From: Linda Boyer
Sent: 29 June 2017 11:09
To: Victoria Walmsley; planning
Cc: Heather Coar
Subject: FW: Consultation on planning application 3/2017/0436 52a Knowsley Road, Wilpshire BB1 9PN
Attachments: 17 0436 Consult.pdf

The application is for a change of house type to Planning Permission 3/2013/0742 to include Velux upstand roof lights, clear glazing to first floor bedroom window in east elevation and sun pipe.

PROPOSED FIRST FLOOR
AND ROOF PLAN

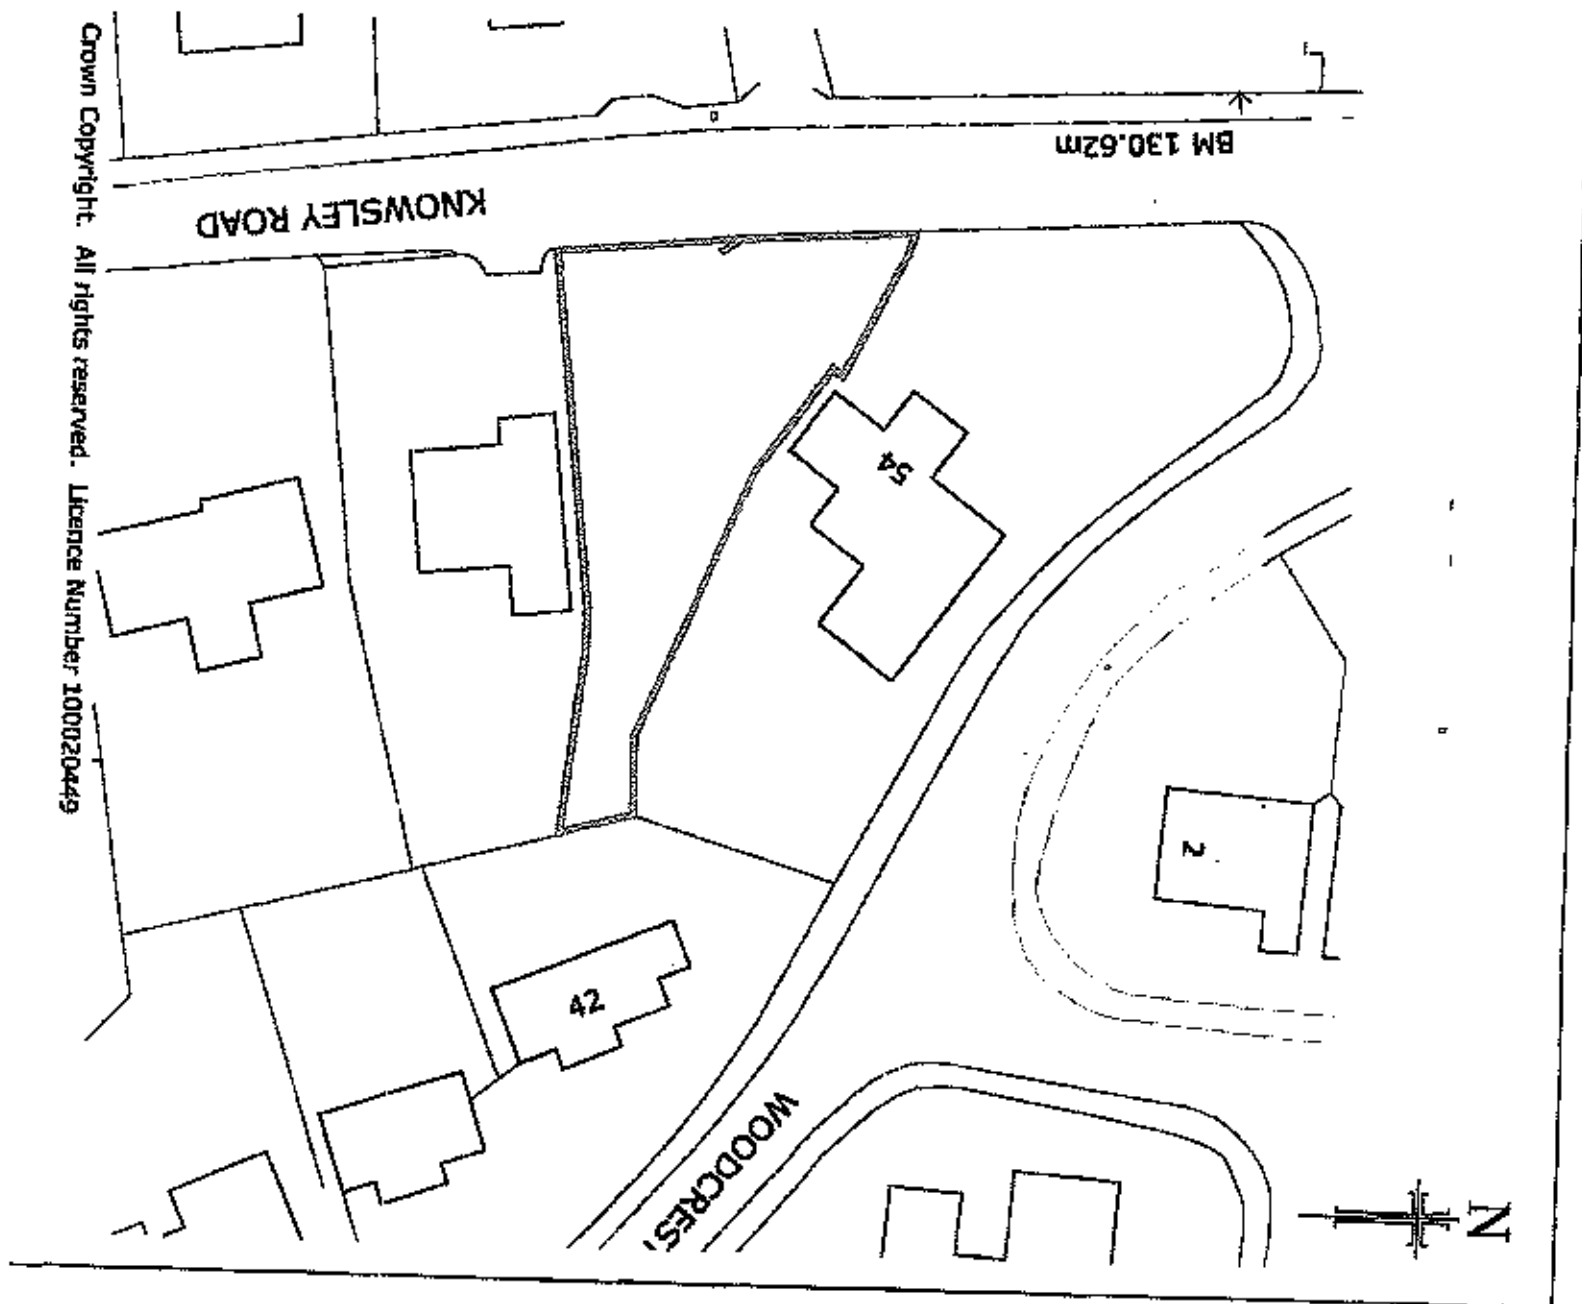
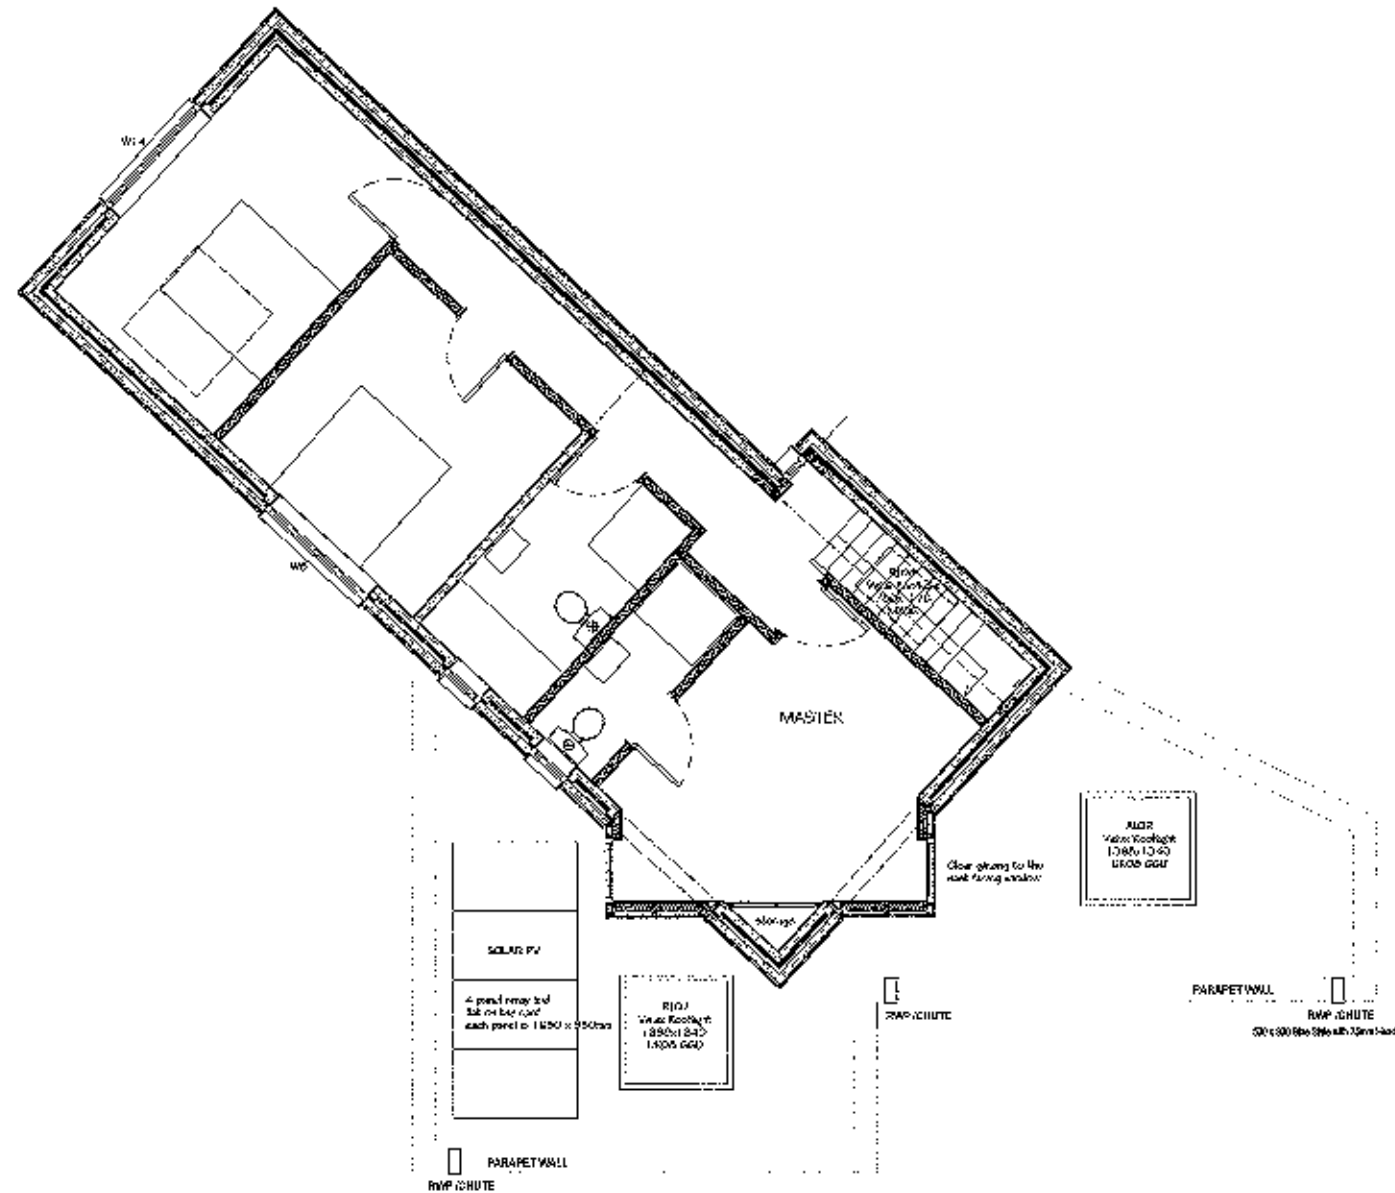
Environmental Health wish to make comments on the planning application above.
We have received a complaint regarding the installation of a pipe light to the above property and the likely occurrence of nuisance from the glare of sunlight on the reflective surface which is affecting the neighbours property. Photographic evidence has been produced which clearly shows the potential for illumination nuisance.
Regards
Linda Boyer
Pollution Control Officer
